SSD 17_8373

ALEXANDRIA PARK

RESPONSE TO

3 OCTOBER 2018
SA6700
REVISED FINAL
PREPARED FOR NSW DEPARTMENT OF EDUCATION

SHADOW DIAGRAMS

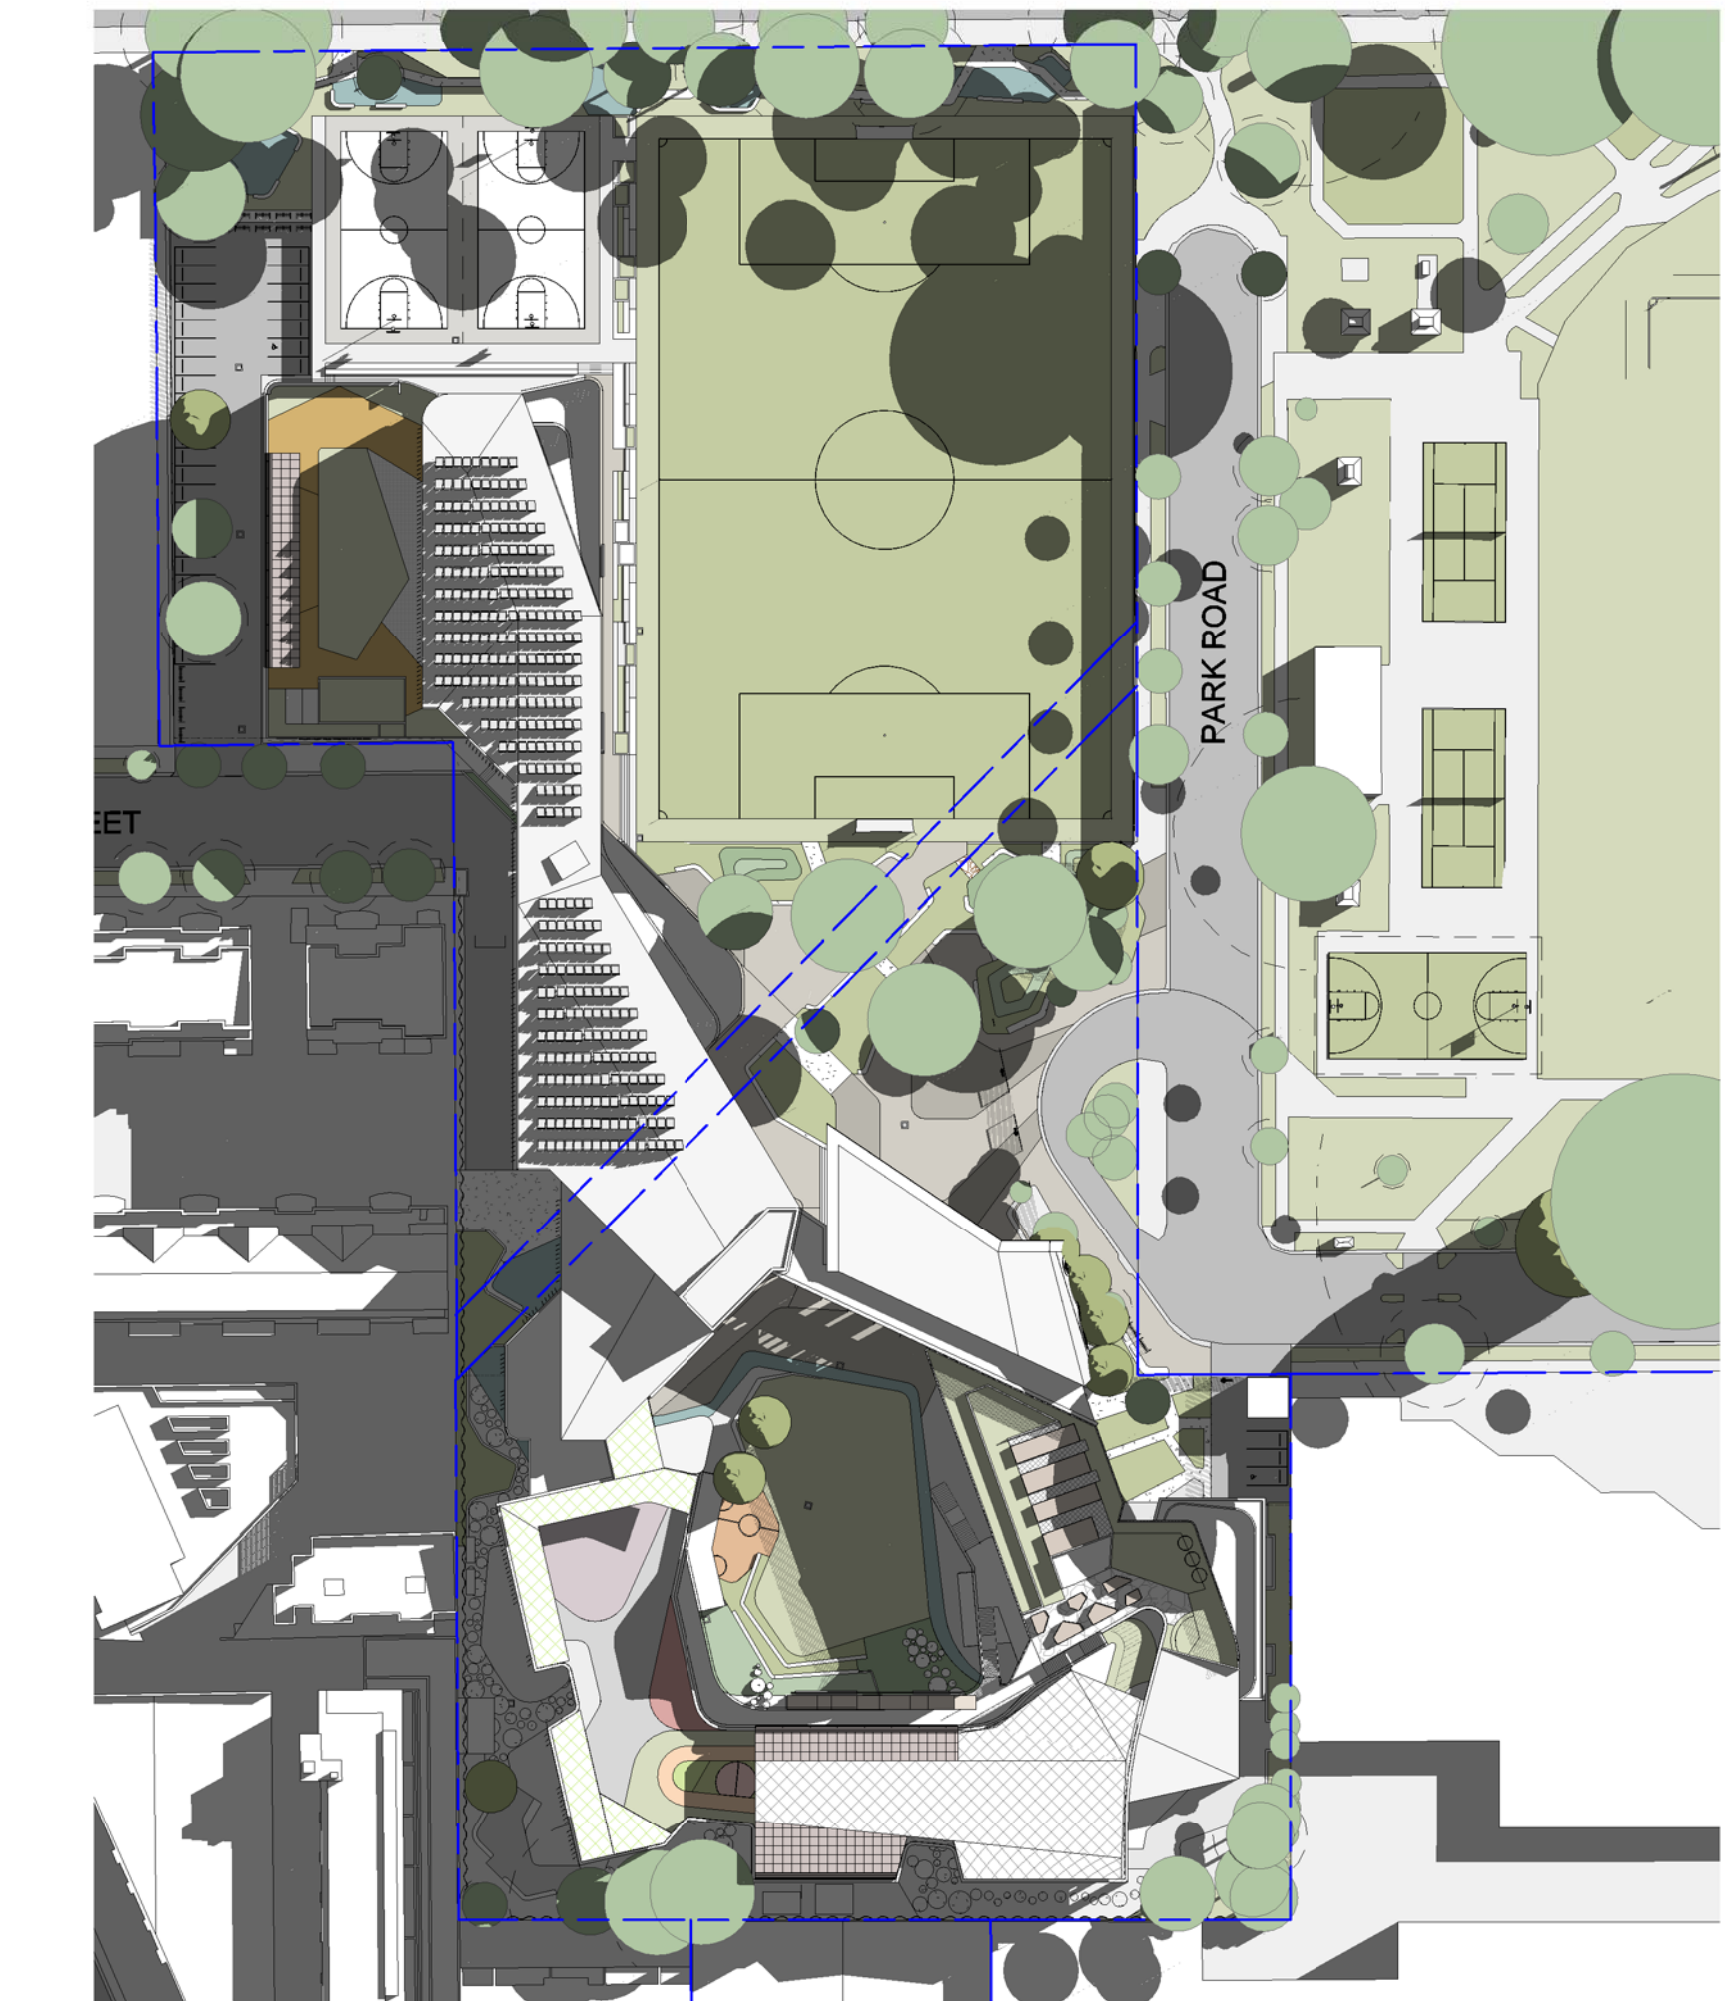
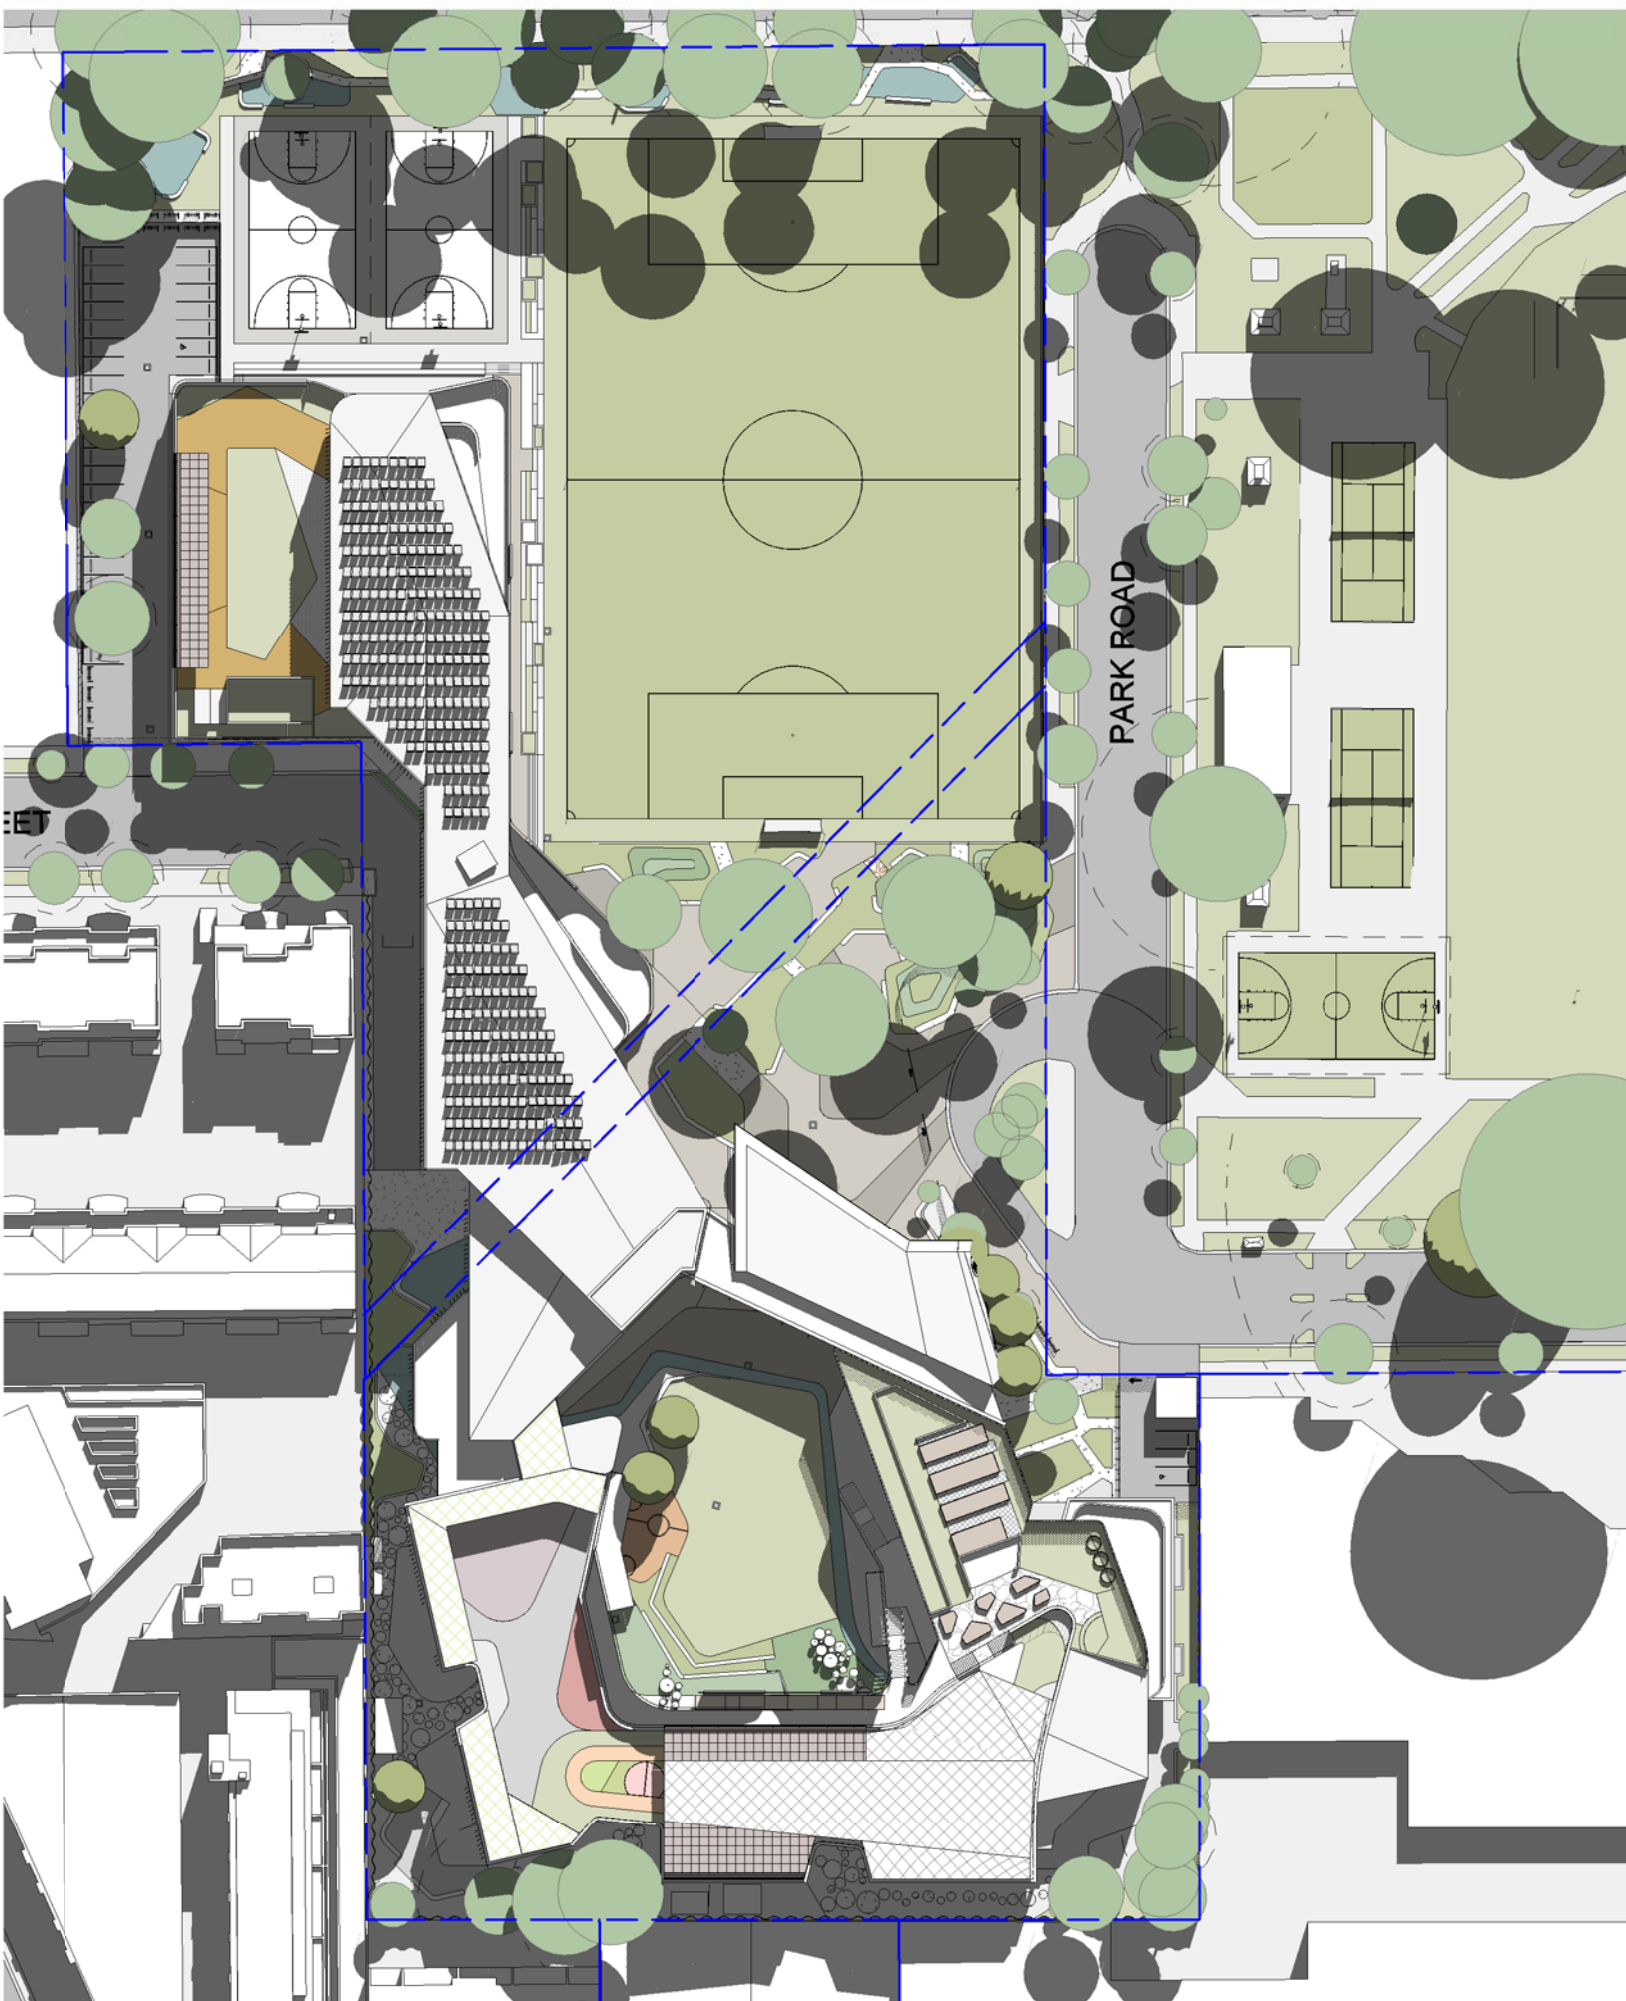
4. Overshadowing	<ul style="list-style-type: none"> The Department notes the comments of the Council regarding overshadowing. Section 6.2.3 of the EIS and Drawing Nos AR.DA.5001 and AR.DA.5002 do not adequately address or depict the shadow impacts of the proposed development upon adjacent properties. 	Refer to the updated Architectural Plans and Urban Design Report at Appendix B and Appendix D respectively for detailed shadow analysis, which is described in Section 3.1 of this RtS report.	Section 3.1, Appendix B and Appendix D

5. Overshadowing	<ul style="list-style-type: none"> A revised assessment of overshadowing impacts at hourly intervals between 9am and 3pm should be provided, including but not limited to: <ul style="list-style-type: none"> more detailed aerial plans detailing existing, height compliant and proposed shadow impacts; and more detailed elevations of affected properties depicting existing, height compliant and proposed shadow impacts and affected windows and room use. 	Refer to the updated Architectural Plans and Urban Design Report at Appendix B and Appendix D respectively for detailed shadow analysis, which is described in Section 3.1 of this RtS report.	Section 3.1, Appendix B and Appendix D

TKD have amended the proposal to improve solar access to 58-60 Belmont Street when compared to the original SSDA. Figure 3 illustrates by shifting the proposed hall 3m north, the Belmont Street building receives much more sun at 2pm in mid-winter. An hour-by-hour analysis of sun access to the northern facing apartments is detailed in Table 1. The table shows that Units 1, 2, 3, 17 and 18 will receive an additional 1-2 hours of sun with the amended proposal. Overall, all apartments will receive at least 2 hours of solar access in mid-winter. This is consistent with the Apartment Design Guide (ADG) and Sydney Development Control Plan 2012 (SDCP). The amended proposal is therefore an improvement and addresses community and agency submissions. This is discussed in more detail in Section 4 of this RtS.

TKD have modulated the primary school home bases to allow greater solar access to 141-143 in response to public submissions. The amended proposal achieves 2 hours of solar access between 9am and 3pm at mid-winter to 17 of the 18 north facing apartments. Unit 8 will receive 1.5 hours of solar access. This is an additional hour when compared to the original SSDA. On balance, the proposed shadow impact is not unreasonable. The amended proposal achieves 2 or more hours of solar access to 95% of north facing apartments, which complies with the ADG and SDCP. The proposal provides significant community and social infrastructure and, on balance, the amended design maintains appropriate level of amenity to adjoining properties.
